ENVIRONMENT PROTECTION AUTHORITY

**Orica Australia P/L, Botany – S.75W Modification- Minor Amendment to Development Consent – DA 30/98 Botany Industrial Park (BIP) – Revision to Conditions**

Appendix 2. Figure YN210058-001, the subdivision as approved in DA No. 2010/486/01

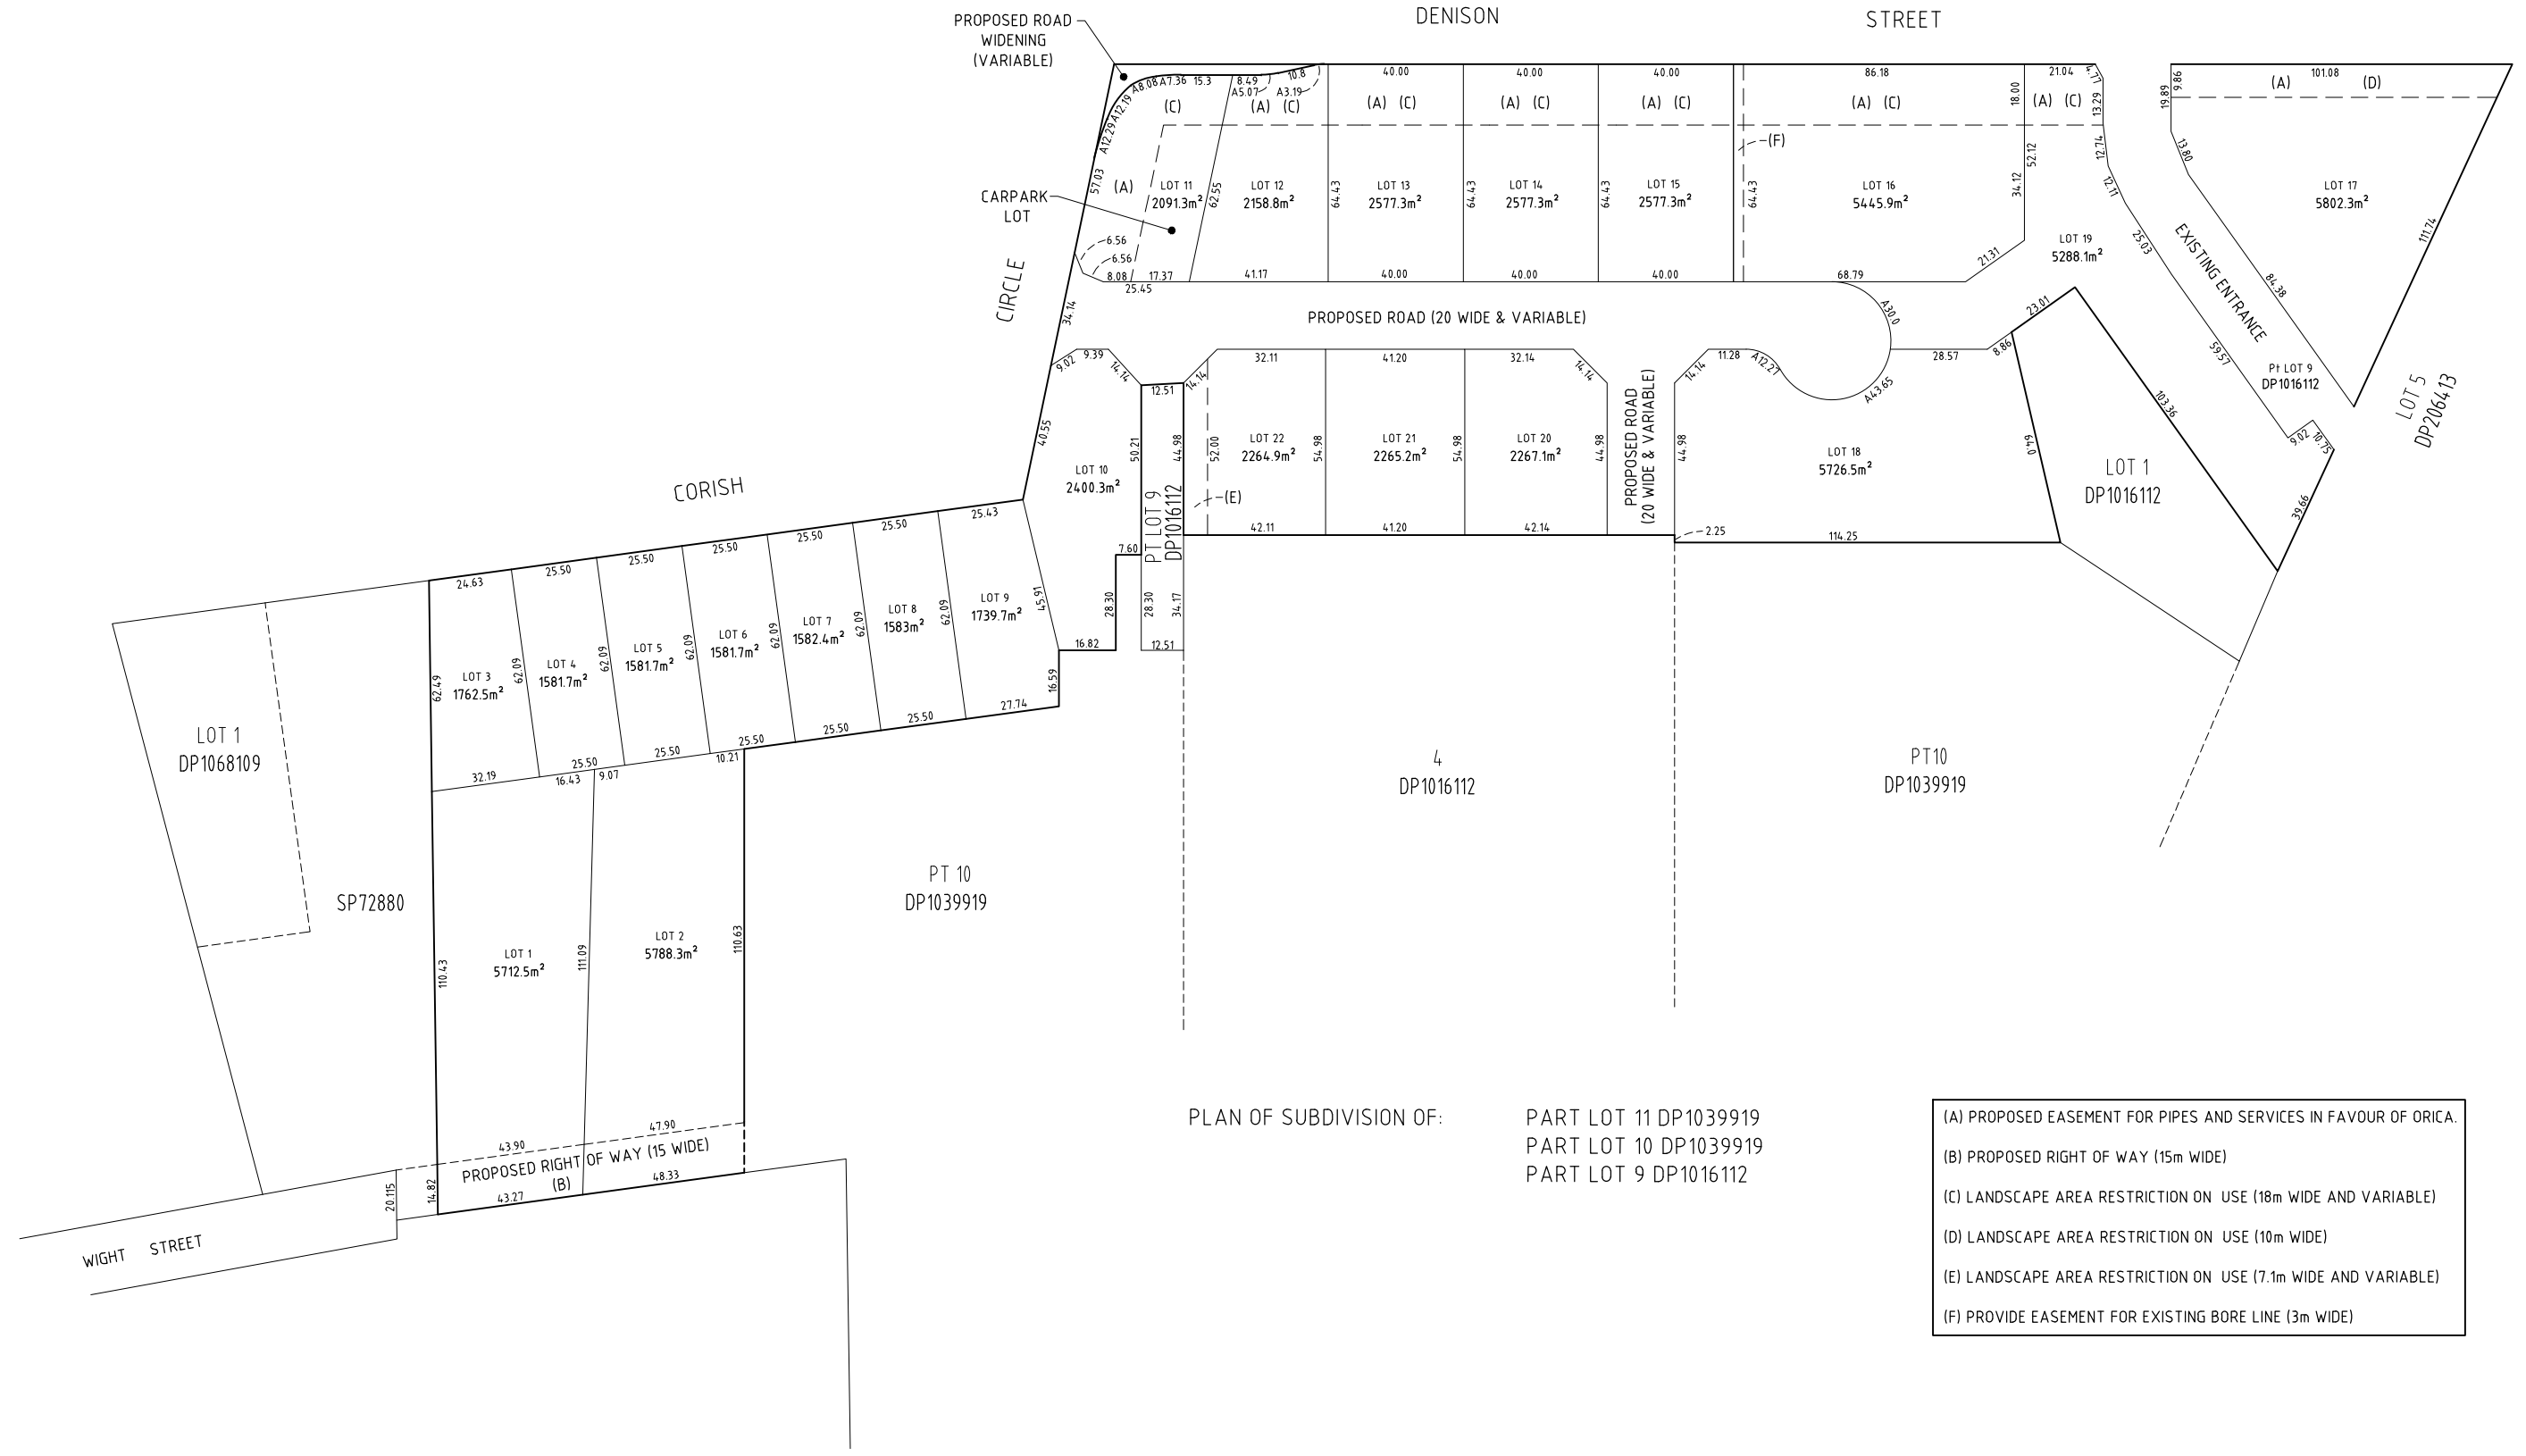
Orica will need to maintain access through an easement or other arrangement to the groundwater monitoring wells located within the proposed excised area for the purpose of completing the CPWE remediation project groundwater monitoring program. The access to the ground water monitoring wells will need to be maintained for a number of years.

Orica will also be required to submit an Environment Protection Licence (EPL) variation to both EPL's 2148 and 13263. The variation will need to include changes to the boundaries, lots sizes and incorporate some of the future groundwater monitoring that is within the boundary of licence 2148.
